Please ask for: Ms Iqraa Malik
Email: iqraa.malik@terraquest.co.uk
Telephone: 01212341390
Our Ref: EP/72/21/HH
Your Ref:
Date: 16th June 2021

Application for Planning Permission for Works or Extension to a Dwelling

Development: Erection of single storey side/rear extension following the demolition of existing garage, shed and conservatory
Location: 8 South Drive Felpham PO22 7PZ

DRAWING No.
001

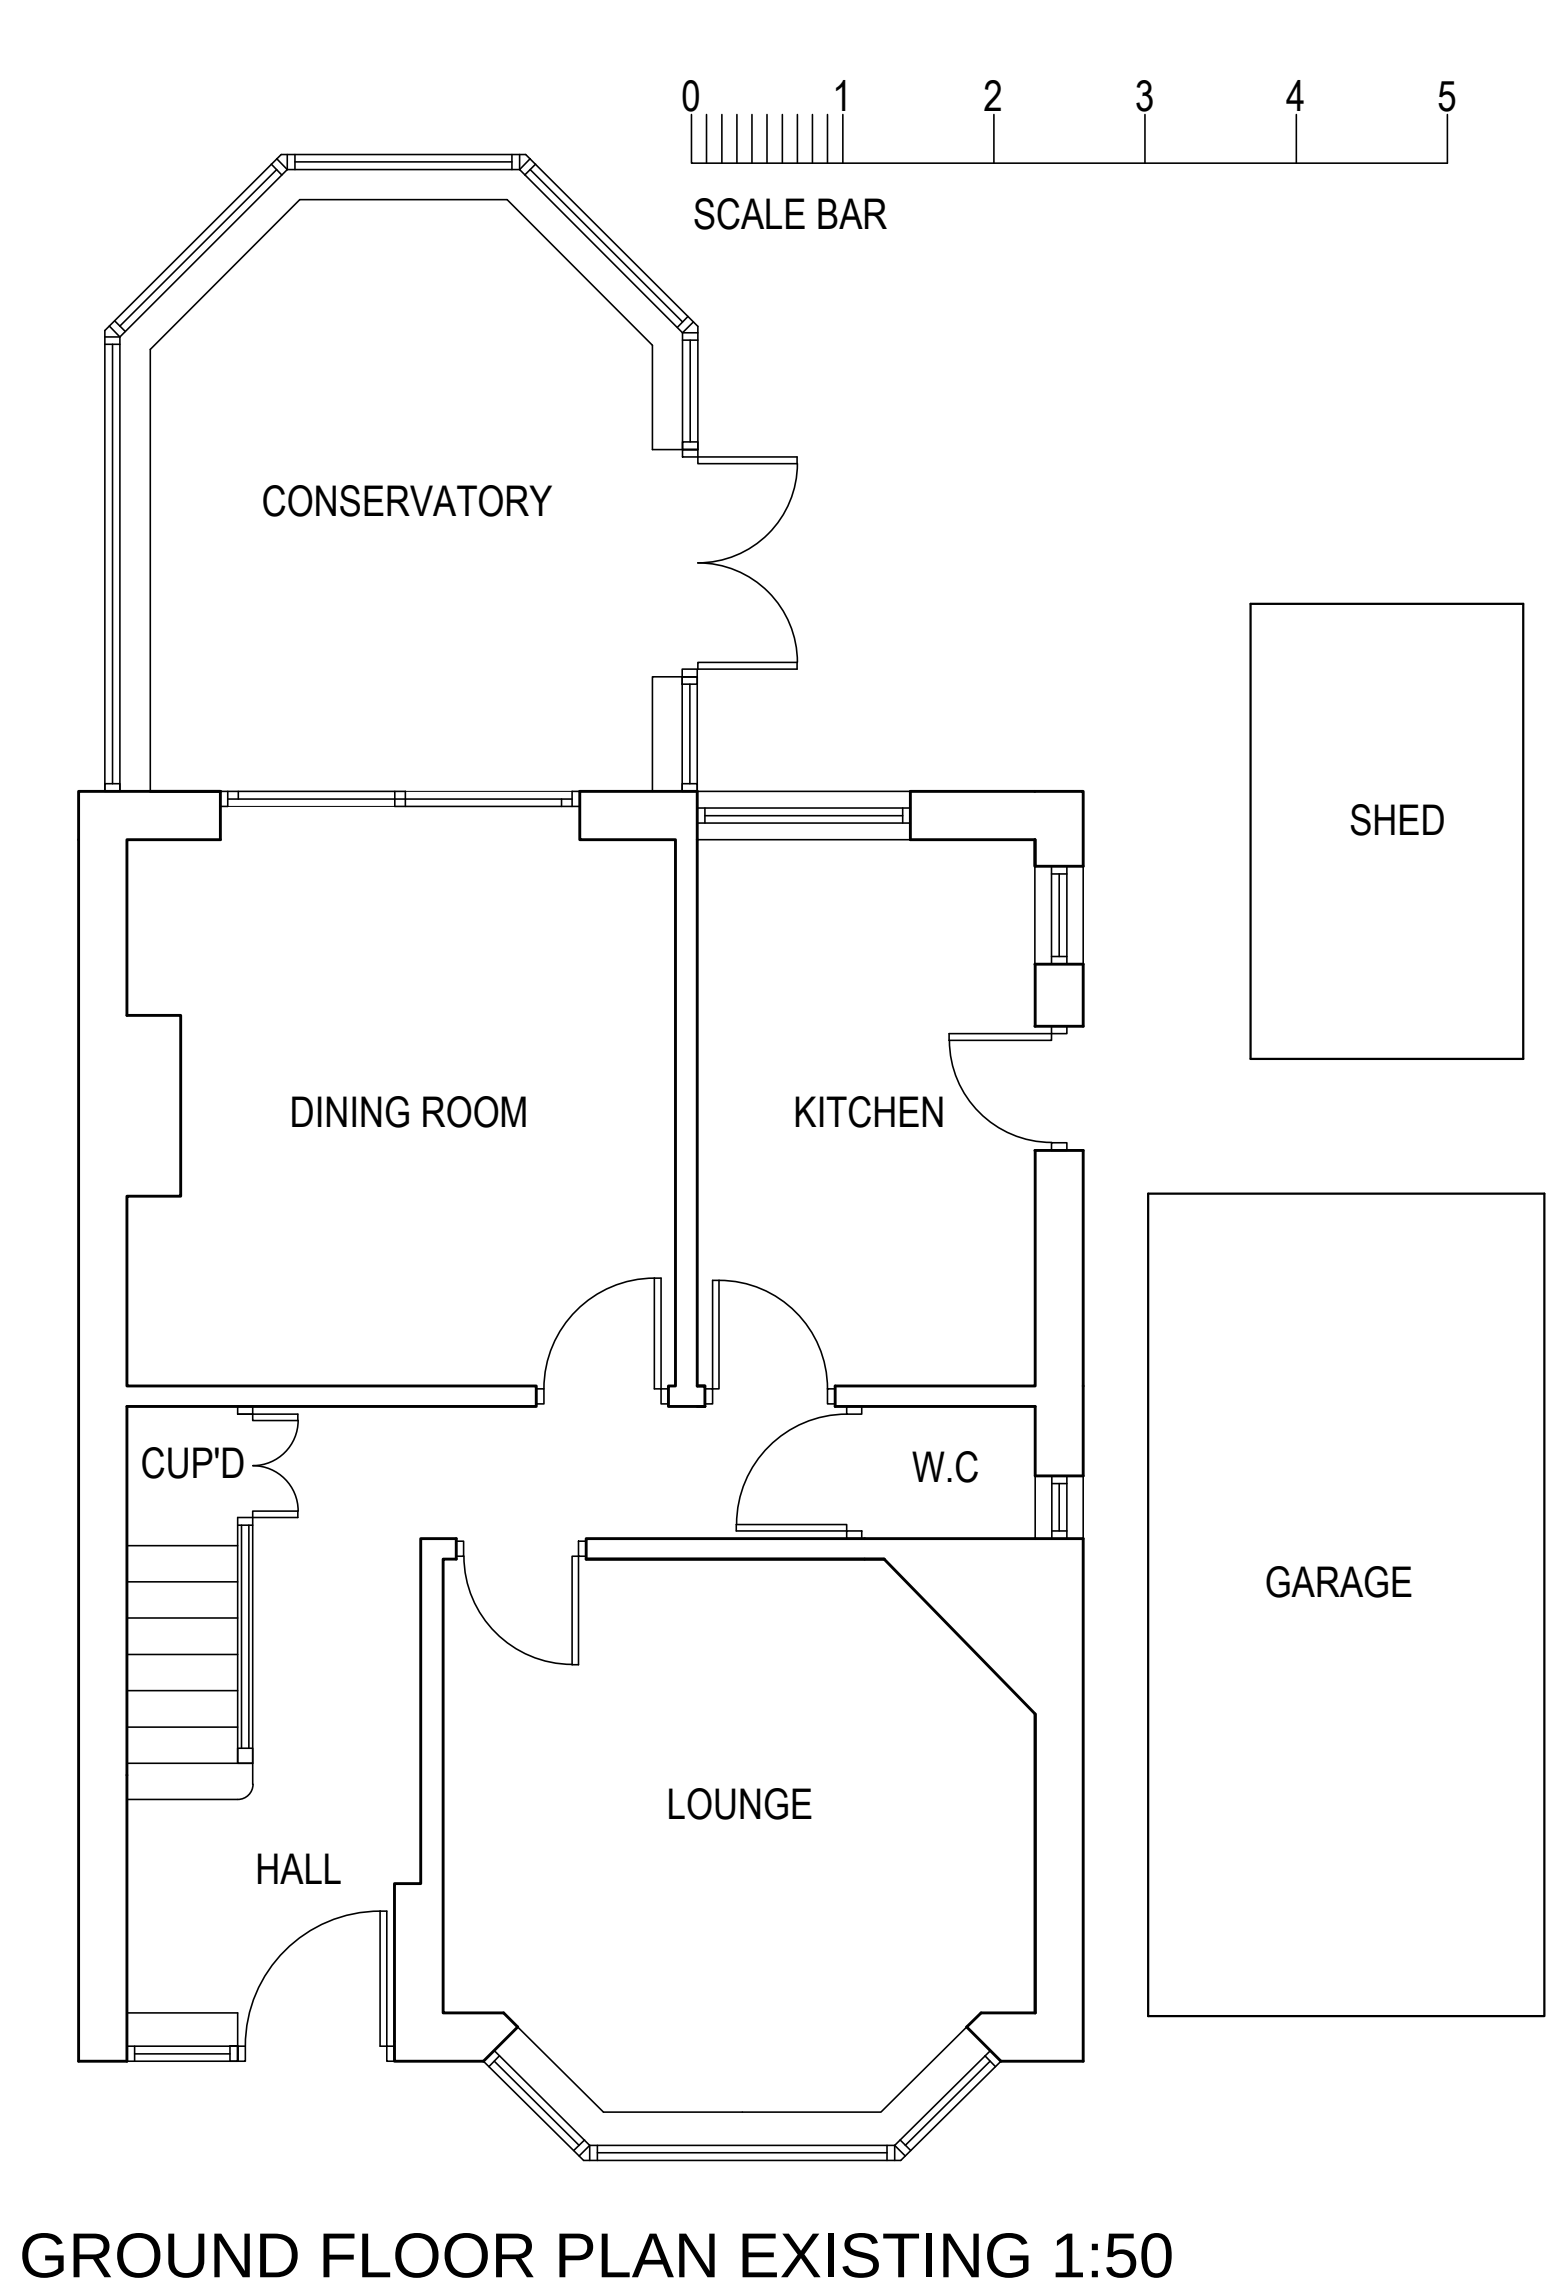
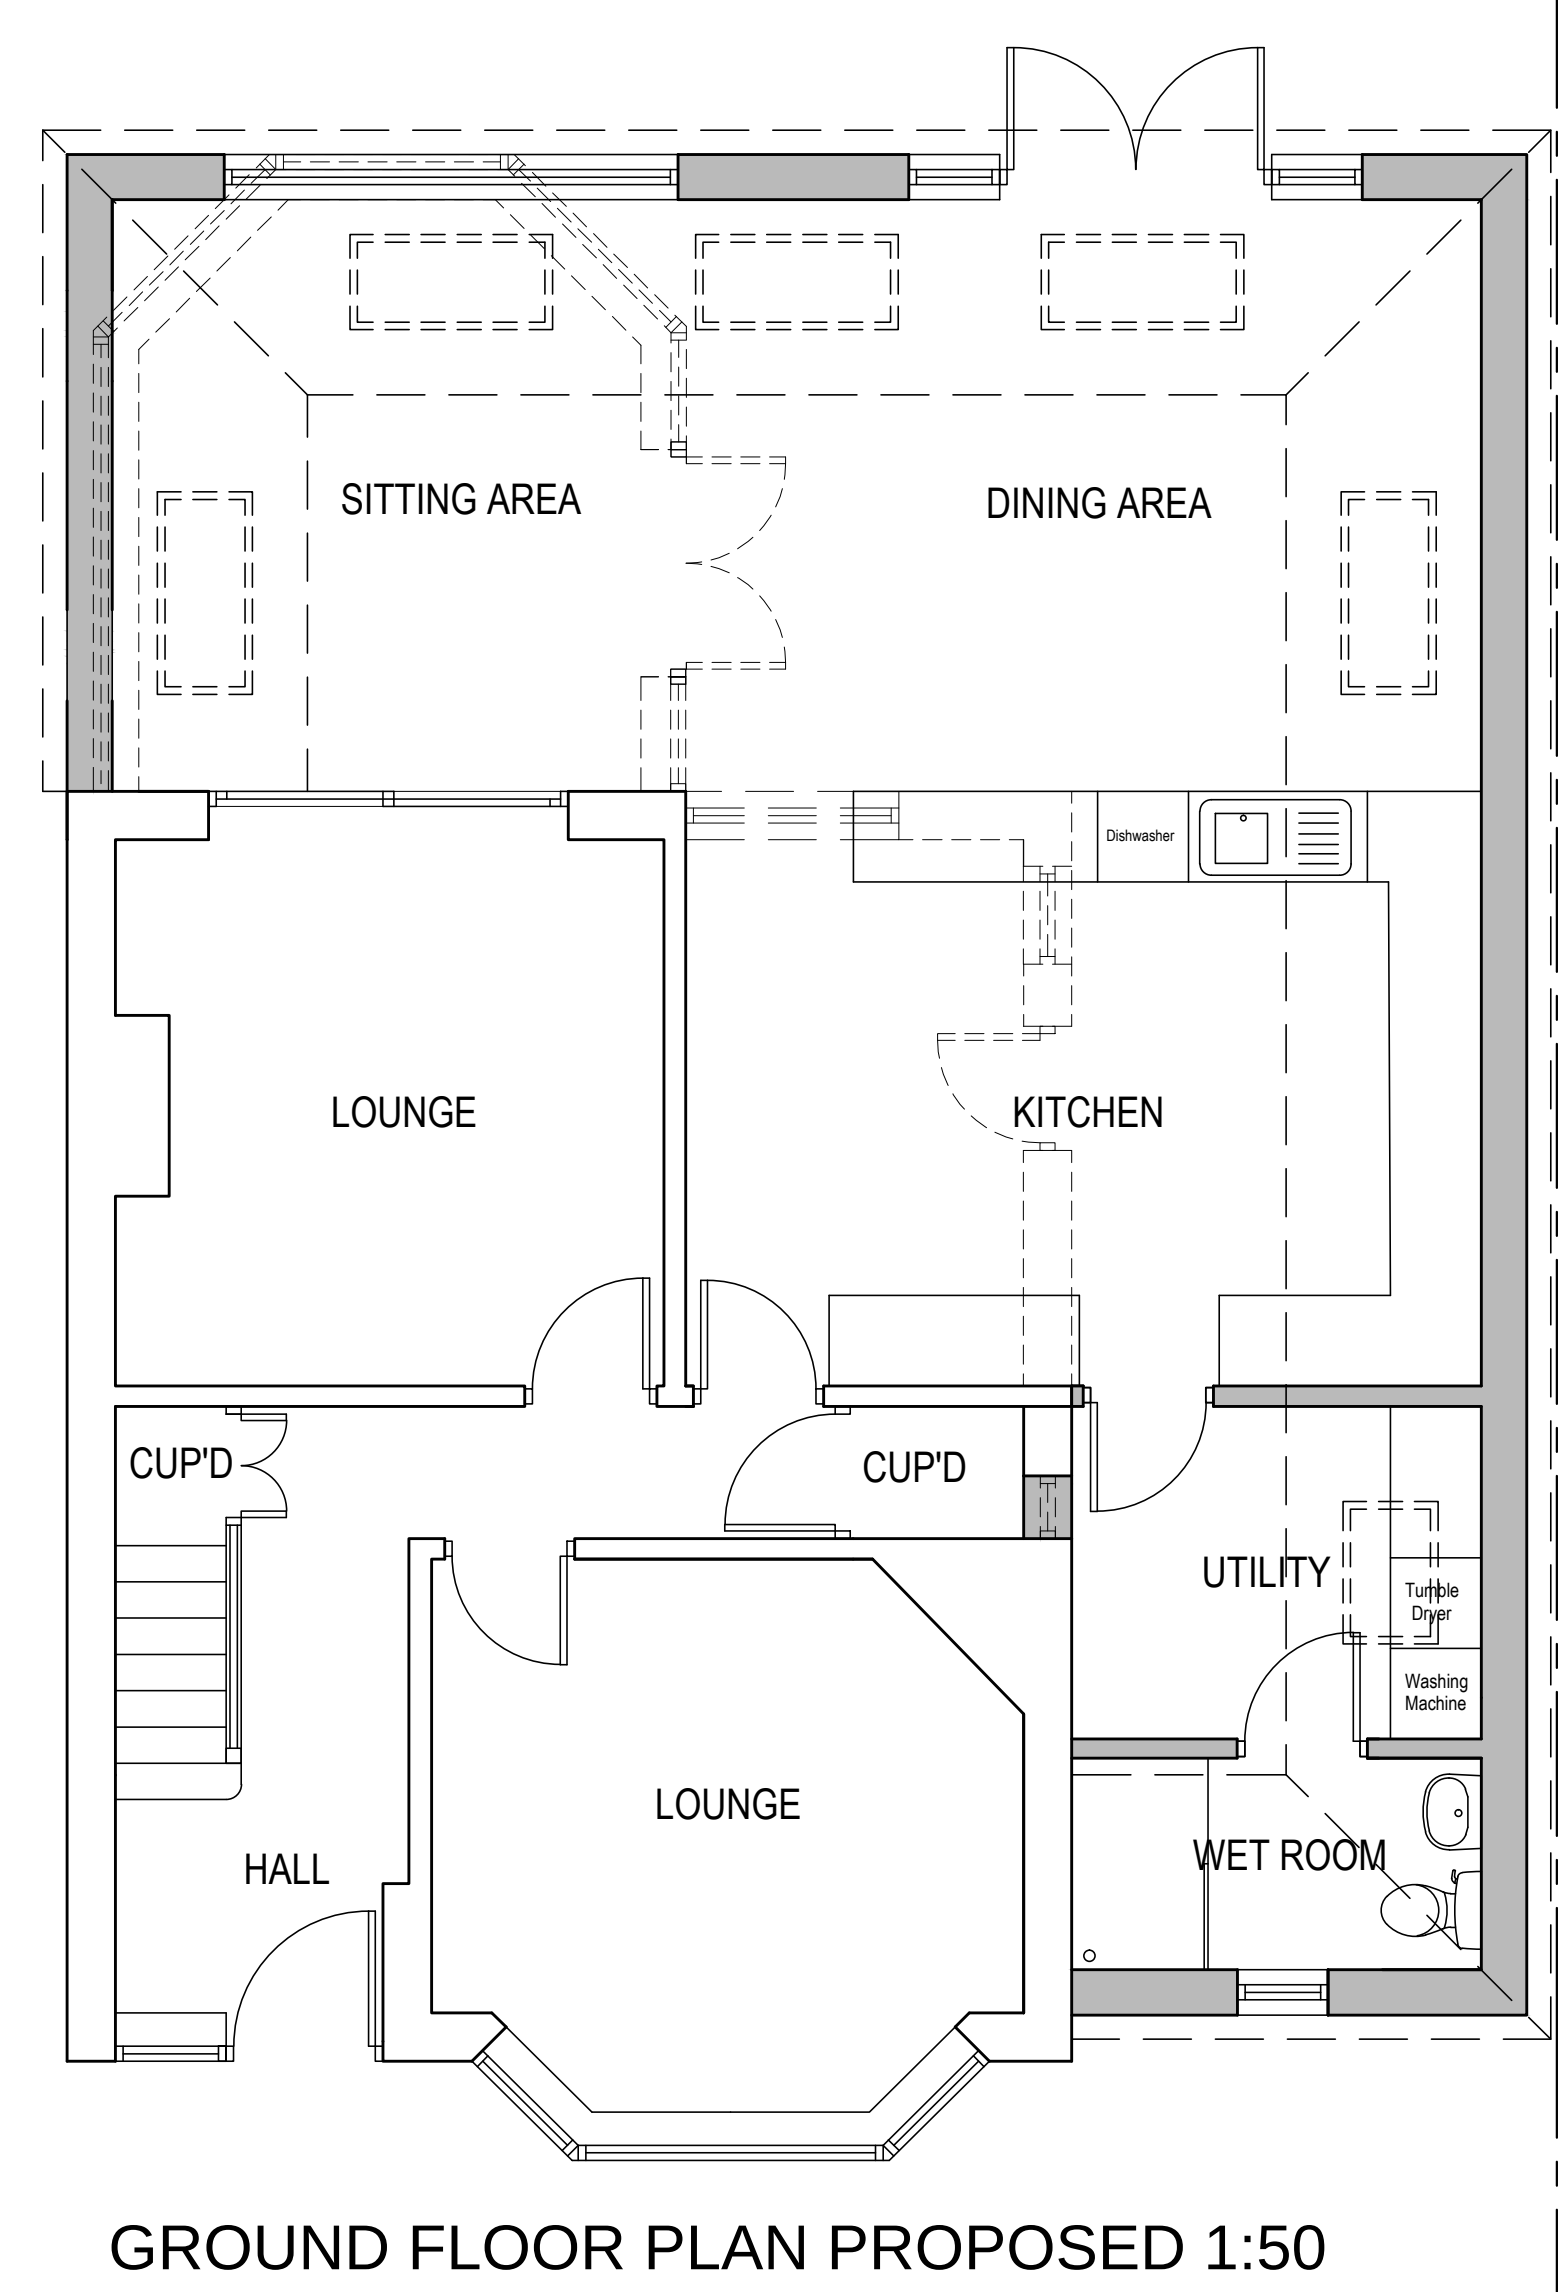
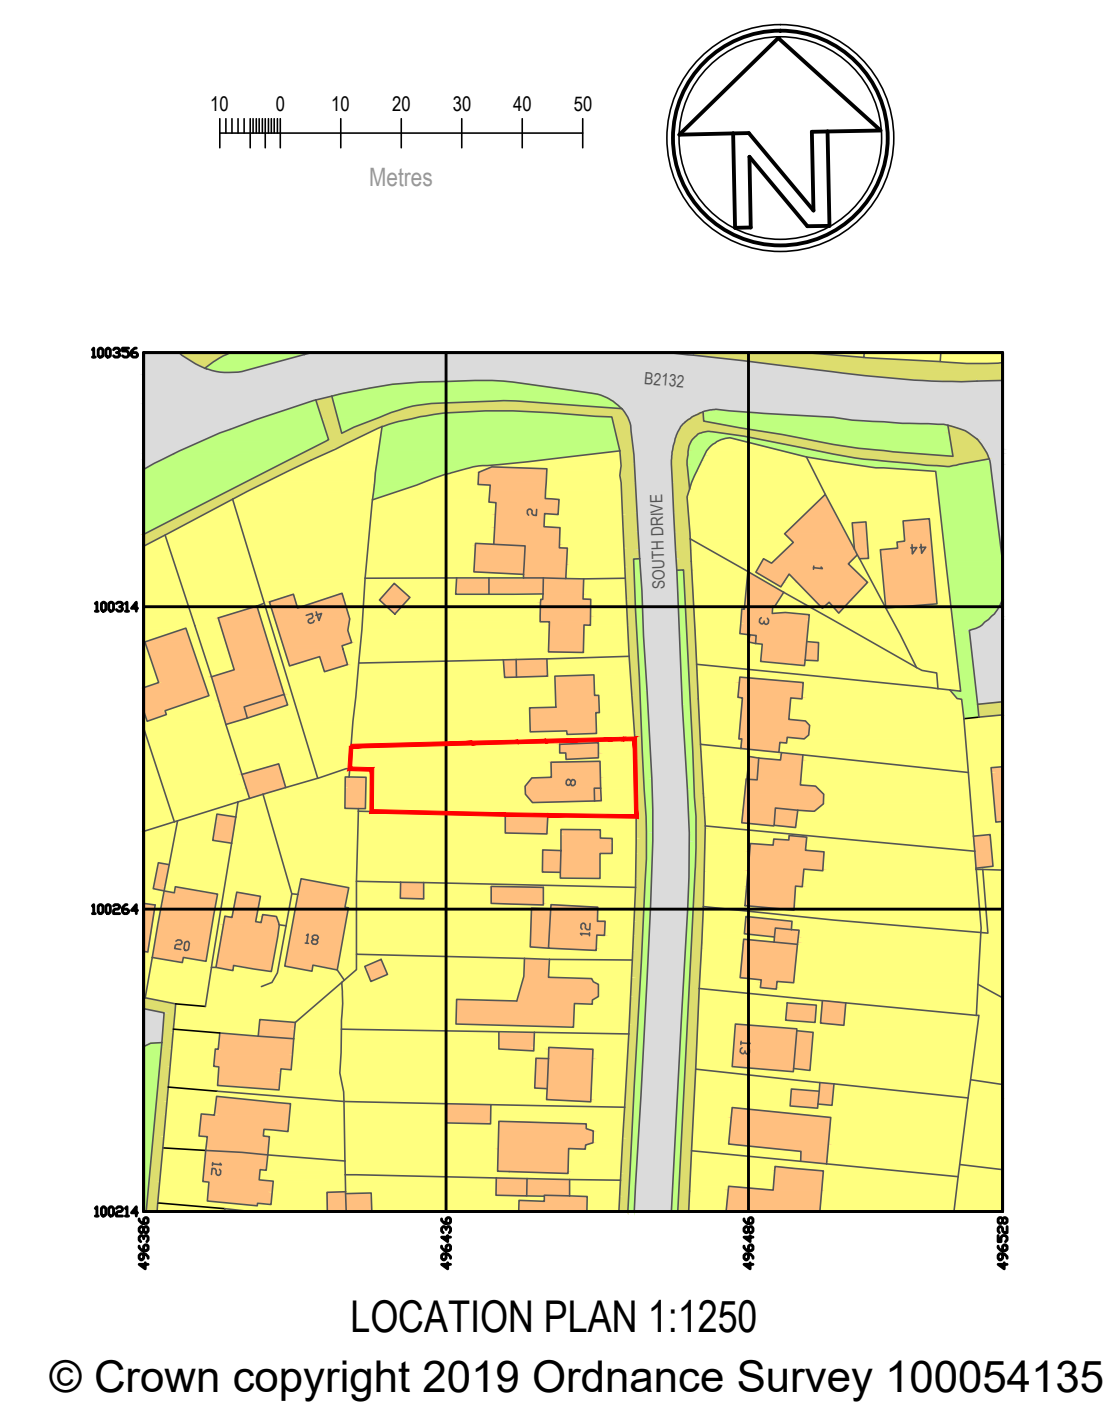
Please add the dimensions from the proposed extension(s) to the front and side boundary
